# CITY OF ALBUQUERQUE

Planning Department  
Brennon Williams, Director

**Re: Dions NM 22**  
**9620 Universe Blvd NW**  
**Traffic Circulation Layout**  
Architect's Stamp 08-03-2021 (B10-D003H)

TRAFFIC CIRCULATION LAYOUT
APPROVED
11/19/21
Date
Signed

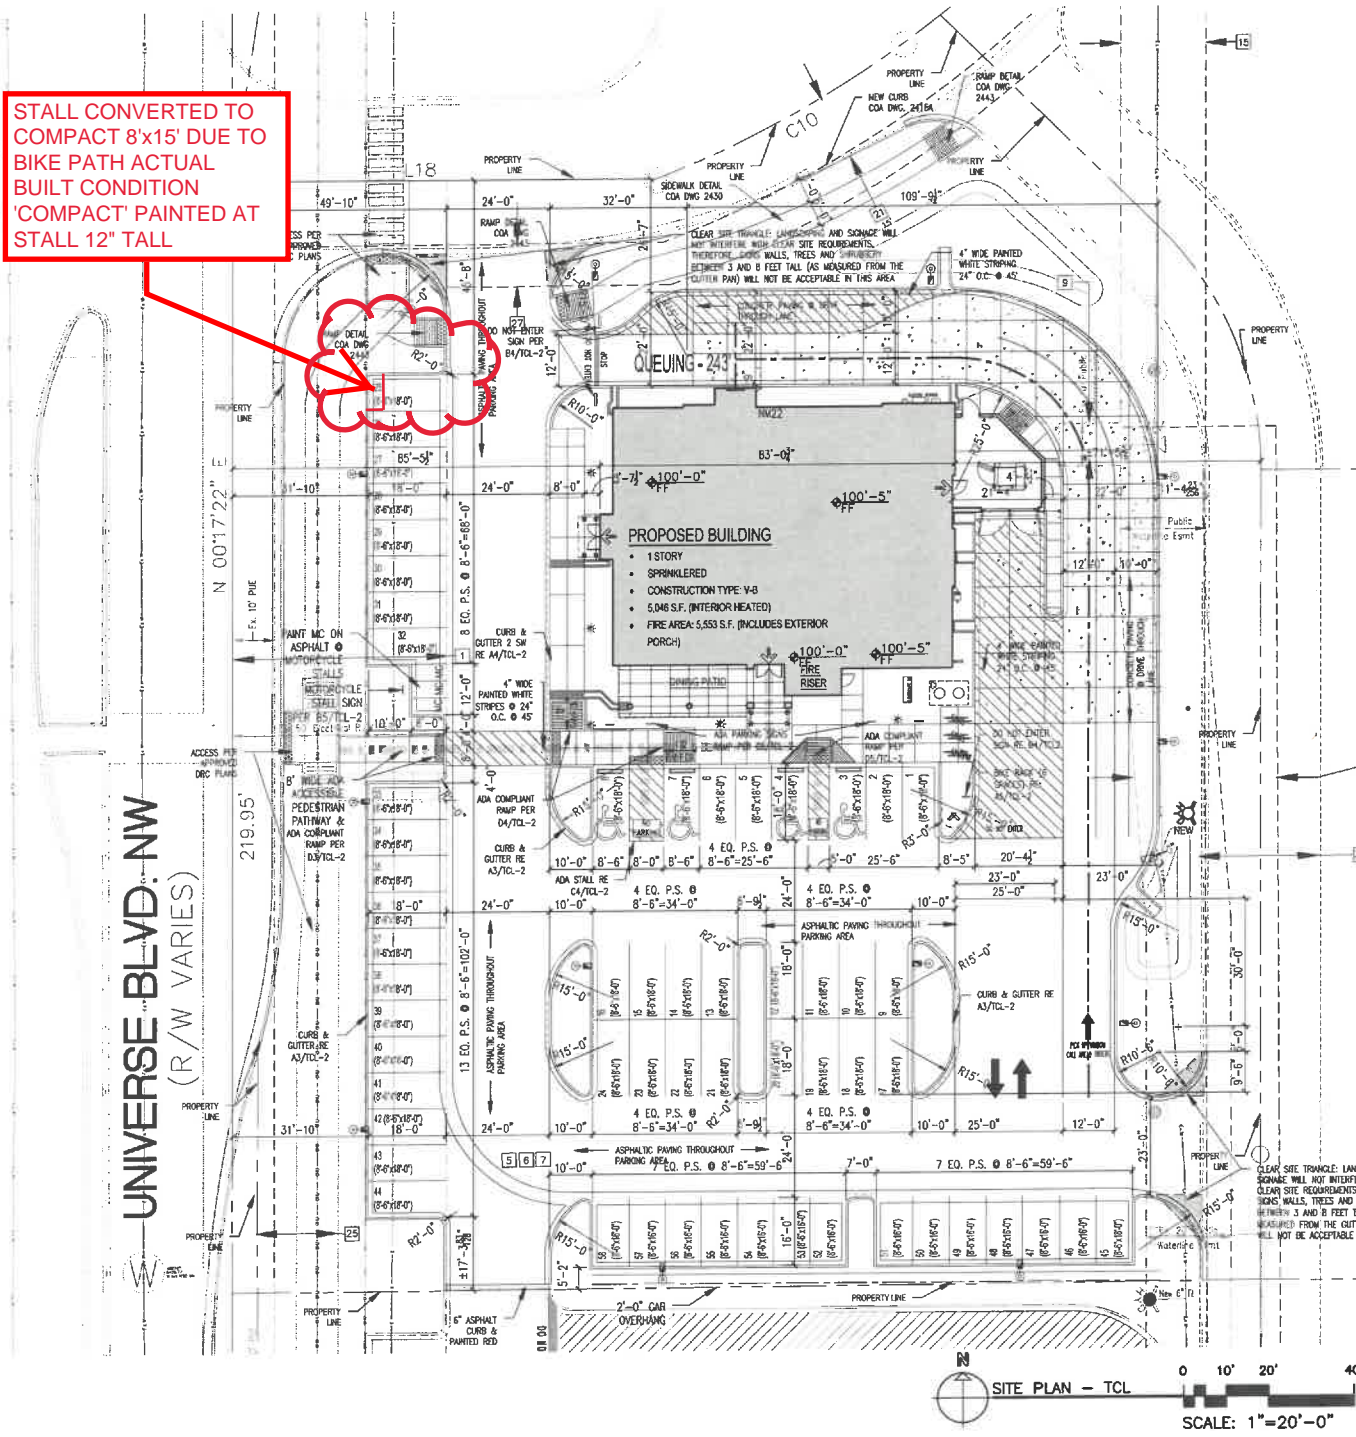
1. Listed are the number of parking spaces required by the IDO as well as the proposed number of parking spaces including bicycle and motorcycle parking.

**Discuss/coordinate with Zoning.**
2. Identify all existing access easements and rights of way width dimensions (If applicable).
3. Identify the right of way width, medians, curb cuts, and street widths on Universe Blvd.

4. Clarify existing property lines and proposed property lines. **Show all of the property line around the perimeter of the lot/track.**
5. **Their appears to be an auxiliary access road on the eastside of proposed development.** Please provide construction notes on this roadway infrastructure and include details of pavement design. The roadway will need to be a minimum of 24 ft for 2 way traffic flow unless the whole width is larger than 24 ft and will be constructed at present time. Include limits of the auxiliary access road for proposed development.

6. Any proposed onsite infrastructure like **curbing will need to be labeled and detail provided.**
7. Provide construction notes at both access points to the existing **primary Access Road.** Include details for **drive aisle entrance infrastructure and auxiliary access road.**

8. **Pavement markings:** Details will be needed for all pavement markings/stripping.
9. At the southern end of drive aisle adjacent to southern lot/tracker, a traffic control device will be needed to alert vehicles of open space.

10. Please list the width and length for all existing and proposed parking spaces. Some dimensions are not shown.
11. **The minimum parking stall dimensions are:**

12. Label the compact parking spaces by placing the words "**COMPACT**" on the pavement of each space.

- ADA curb ramps must be updated to current standards and have truncated domes installed as the access road entrance.
- The **existing ramp at corner of Universe/Access Road** doesn't line up with what appears to be sidewalk/asphalt trail connectons. Please clarify this concern.
- The **existing ramp and sidewalk** along the Universe Blvd frontage segment will need a **Sidewalk Easement** since its location is on private property.
- Will an ADA ramp be needed for existing median cut? **Explain situation.**

14. Motorcycle parking spaces: **Label pavement MC.**

19. Show all drive aisle widths and radii. Some dimensions are not shown.

21. List radii for all curves shown; for passenger vehicles. **Radius for delivery trucks, fire trucks, etc. is 25 ft. or larger. Provide FD approval for proposed layout.**

27. All one-way drives shall have “One Way” and “Do Not Enter” **SIGNAGE** and pavement markings. Please show detail and **location of posted signs** and striping.

28. The minimum drive through lane width is 12 feet with a 25 foot minimum radius (inside edge) for all turns. (A 15 foot radius can be used with an increase in lane width to 14 feet). **Please dimension all lane widths and radii.**
